**Proposal:** Discharge of Conditions 7 (Finished Floor Levels), 8 (Materials), 13 (Trees and Landscaping), 16 (Car parking) and 17 (Cycle parking) of 19/02275/F.

1.1. New Technical Site – Bicester Motion

TITLE:
Building 141 Proposed SE and SW GA Elevations

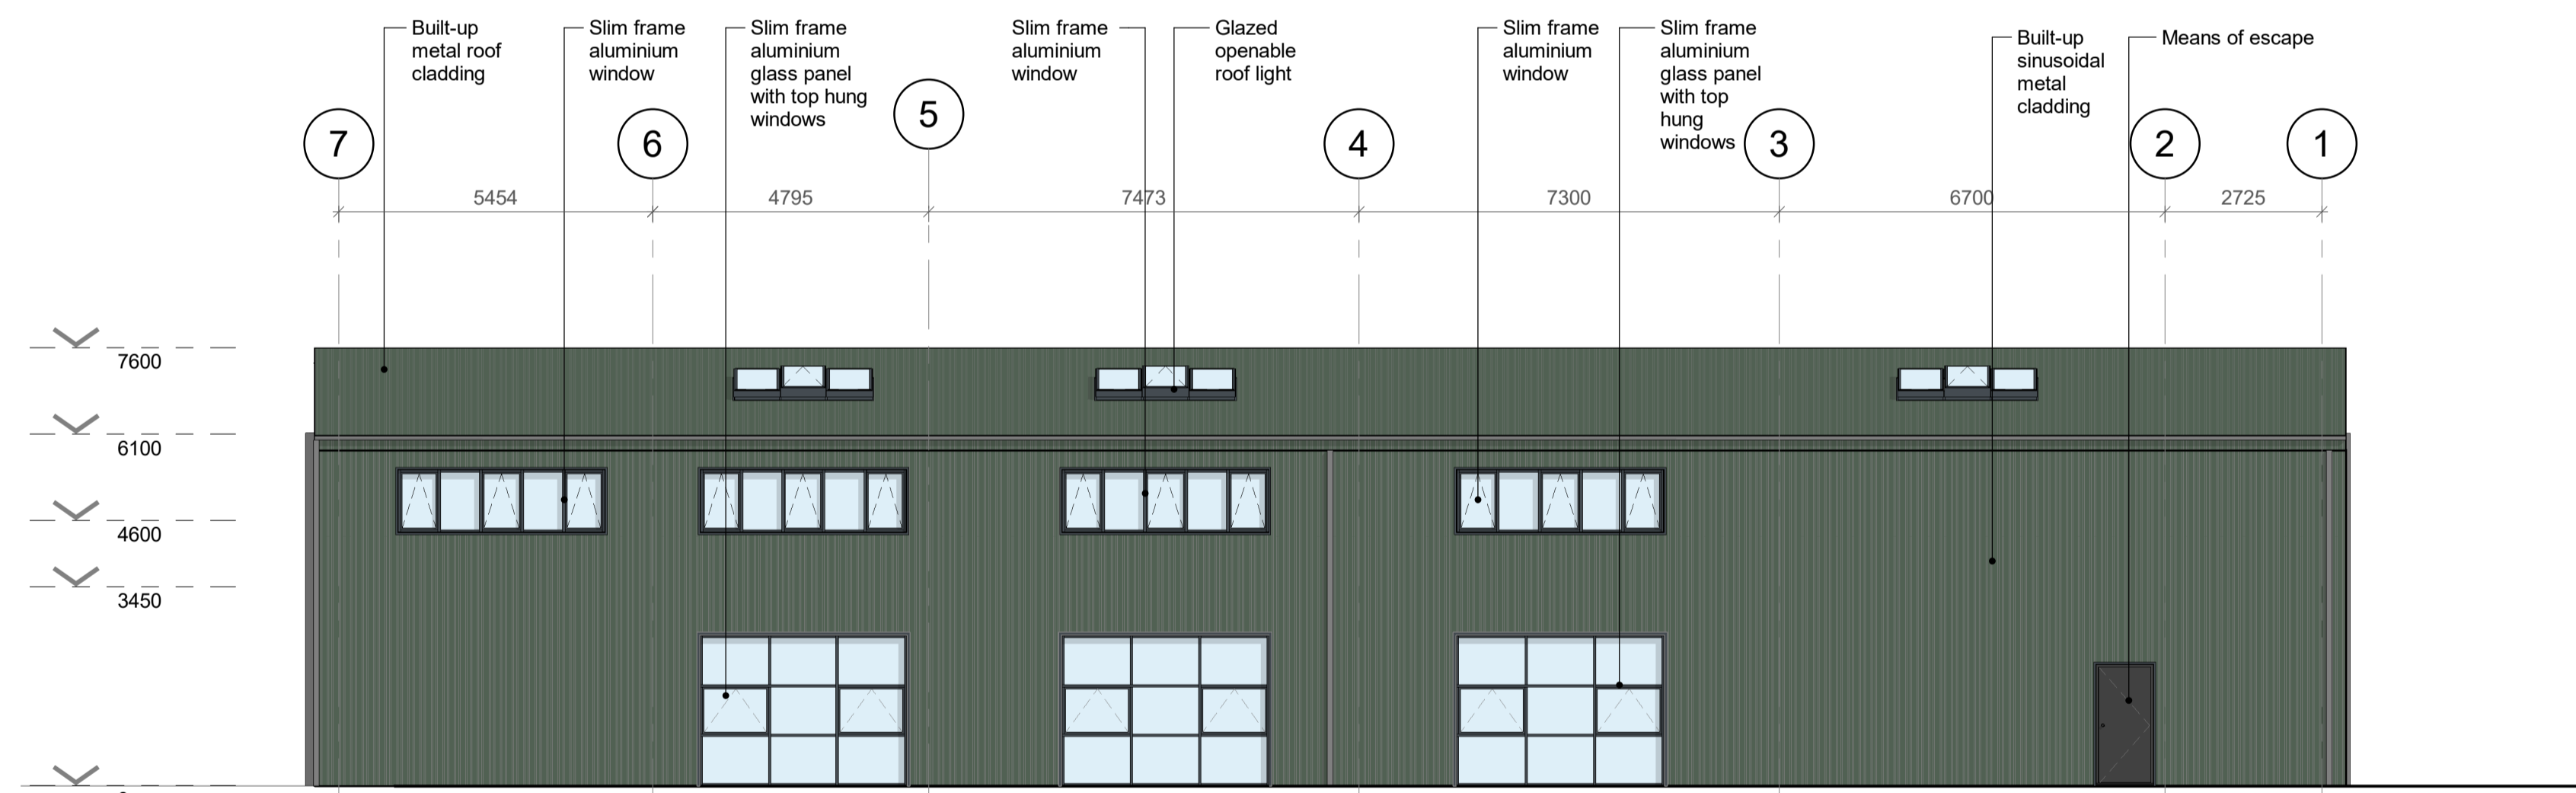
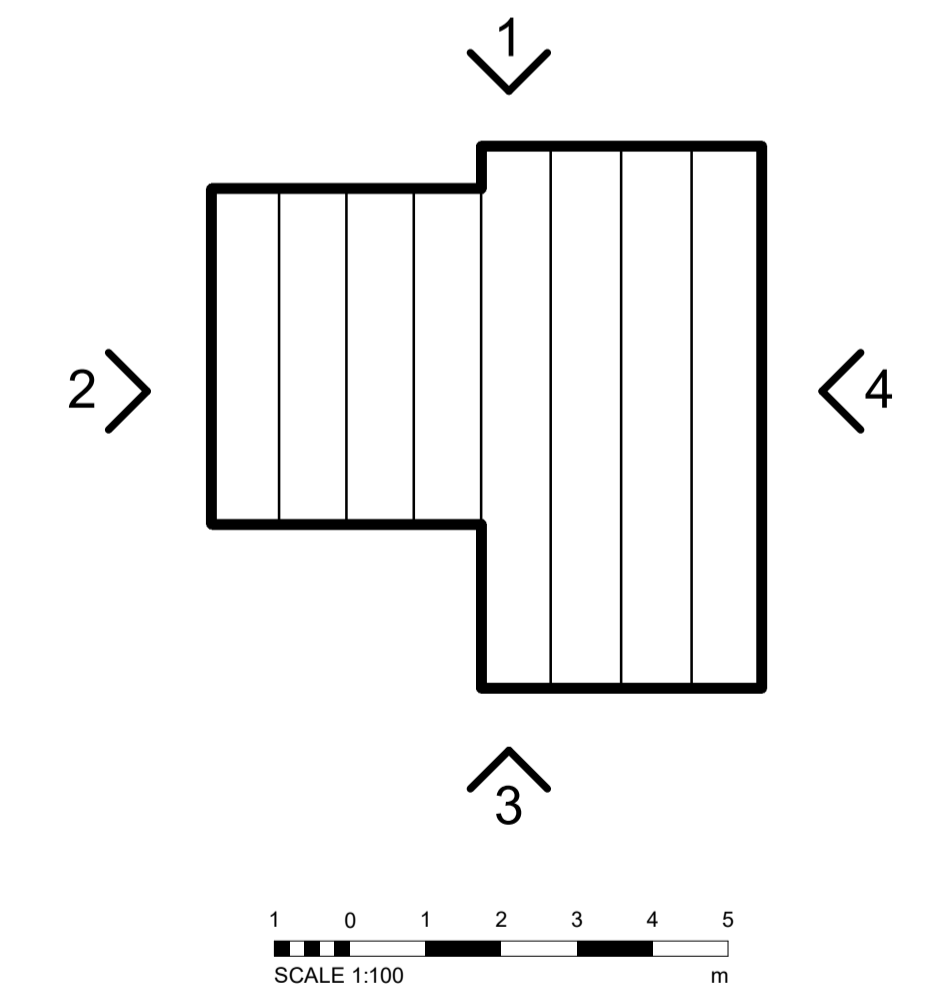
- 7.2. Condition 8 (Materials) – Material samples of the bricks (including a sample panel), cladding, window detail, fascia, guttering and external lights were viewed on site on 6<sup>th</sup> November 2019.

The proposed materials reflect the approved design in terms of type and colour. The bricks have been carefully considered to reflect the existing historic bricks used on the old technical site in terms of colour variation.

The proposed materials are considered to be acceptable for the development and it is recommended the condition is discharged.
